DECISION DELEGATED TO DEVELOPMENT MANAGER

Application No: H06-0127-20 **Applicant:** Hartlake Properties Ltd.
Proposal: Proposed single storey rear extension
Location: Paynton Main Road Gedney Drove End
Terminal Date: 9th May 2020

Planning Proposed Front
Scale 1 : 100

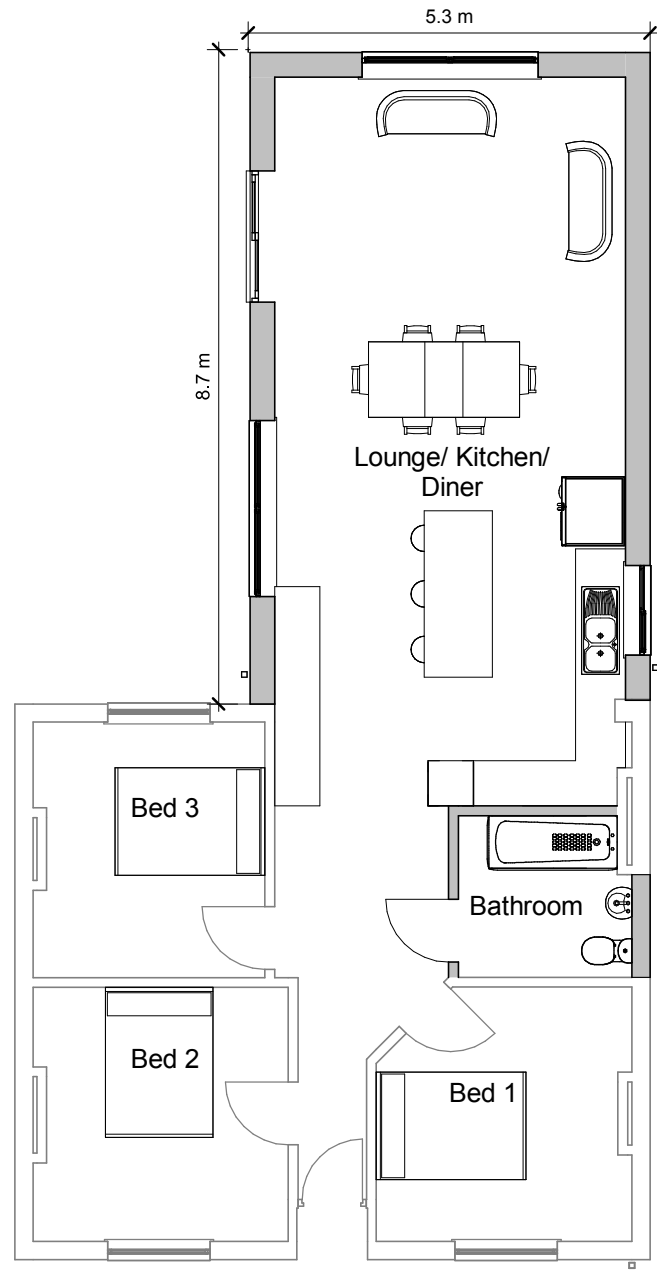
The proposed extension will project 8.7 metres from the original rear wall of the bungalow onto the rear garden. The width will be 5.3 metres which is slightly more than half of the full width of the building. The apex height will be 5 metres (less than the ridge height of the existing dwelling) and the eaves as much as those of the existing property. Having regard to the dimensions of the residential building, the proposed development will be subservient to the host property in terms of scale, massing and bulk.

Whilst the existing extension has a high lean-to pitch facing the east and it drops gradually to become a flat roof, a hip roof will be across the full proposed extension. The new roof layout will deliver a more congruous form of development than the existing addition to the rear. Furthermore, it

The proposed apex height will be 5 metres in contrast with 3.70 metre height of the existing lean-to. However, the lean-to element merges with the eastern side elevation where the roof is currently highest, but the ridge of the proposed extension will be instead set back 2.70 metres from this elevation and the eaves only as high as the existing property's. Therefore, any overbearing effect might be in fact reduced by virtue of the proposal as submitted.

Proposed Ground Floor
Scale 1 : 100

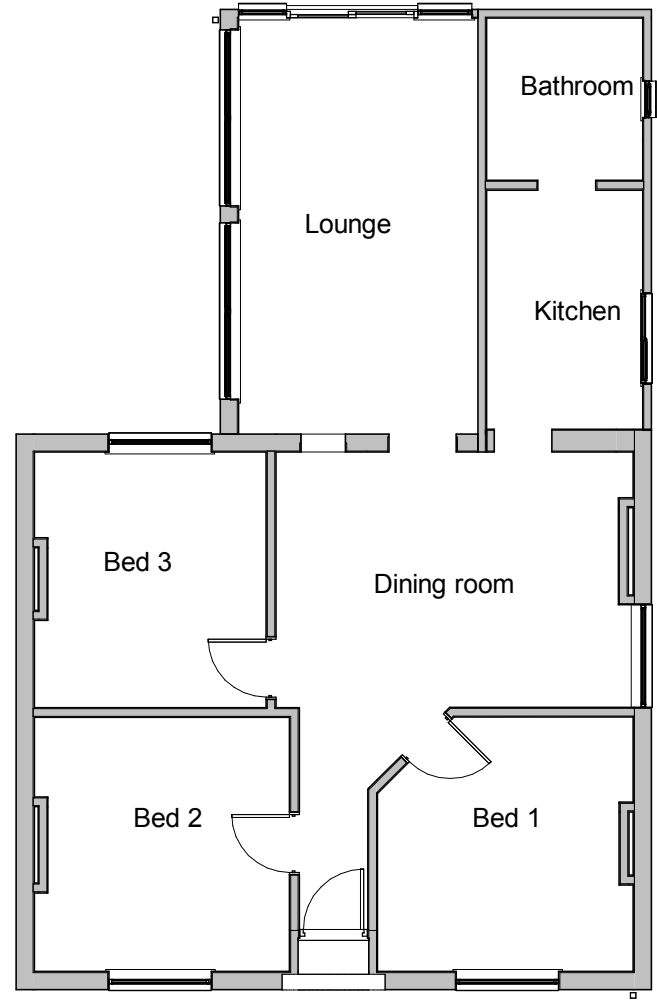
The aim of the proposal is to increase the floorspace and re-arrange the internal rooms. The current extension hosts a lounge, kitchen and bathroom. The proposed enlargement will accommodate a large lounge/kitchen/dining room. The bathroom will be relocated side-by-side with bedroom 1. The nature of development is clearly keeping with the residential use of the building and will meet the needs of the current occupiers.

Proposed Site Plan
Scale 1 : 500

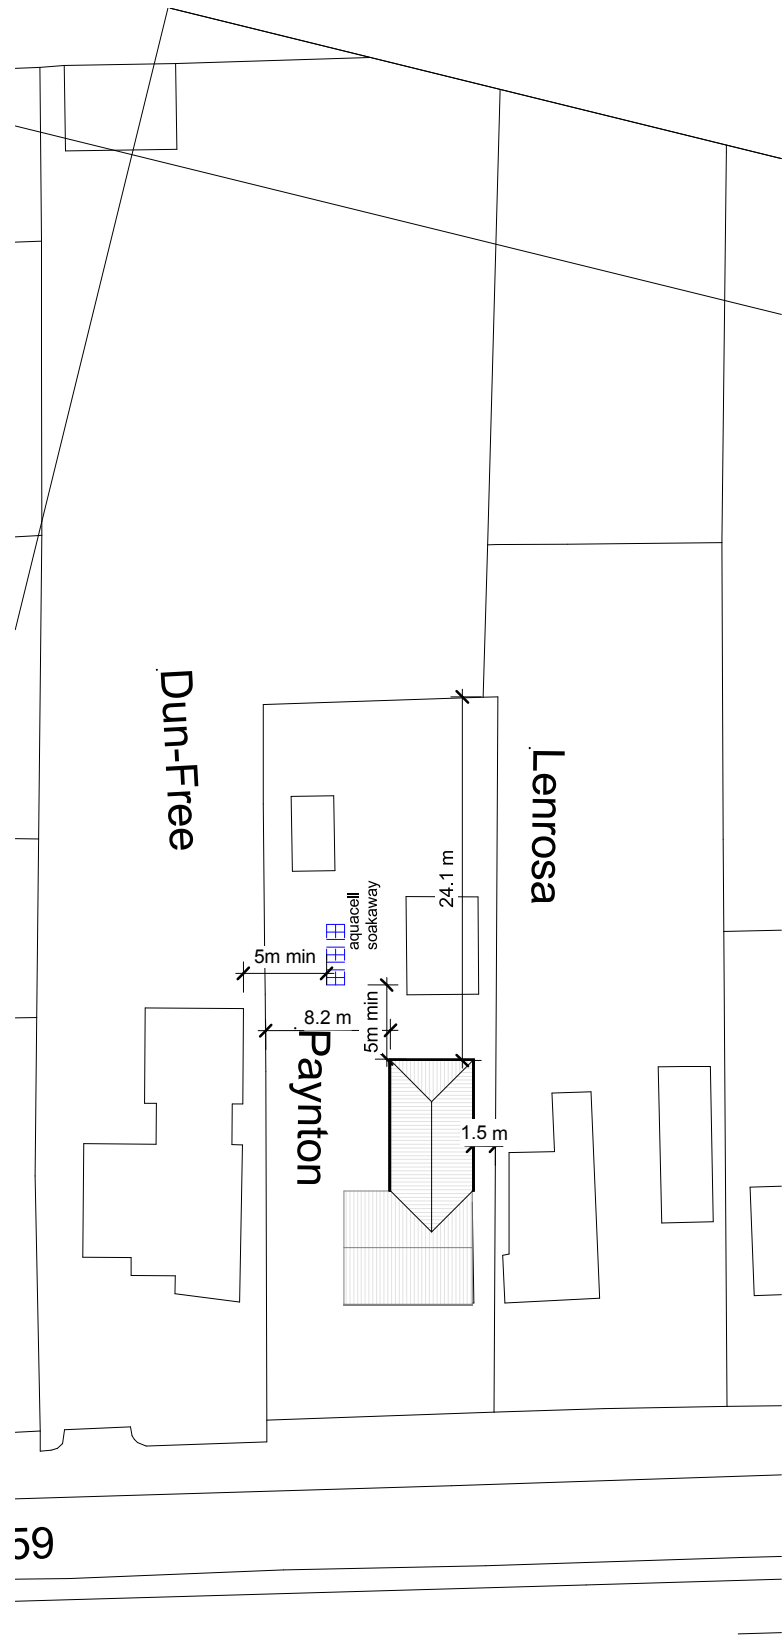
Gedney Drove End has the highest flood hazard according to South East Lincolnshire Strategic Flood Risk Assessment (March 2017). Under case officer's request, revised plans have been submitted to incorporate the installation of soakaway in the rear garden to manage sustainably the surface water runoff coming from the proposed extension. In doing so, the design of the development is appropriately resilient to the effects of flood risk and overall climate change following Policy 4 of SELLP. No evidence of poor soil permeability is known in the locality. In any case, the suitability of a soakaway will be tested and subsequently approved at a later stage by SHDC Building Control.

The footprint of the extension appears 1.5 metres from the eastern boundary, 24.1 metres from the rear boundary and 8.2 metres from the western boundary. Being single-storey in nature and having a 5 metre maximum height, the development will not cause at such separation distances any detrimental to the amenity standards of residents of adjacent properties.
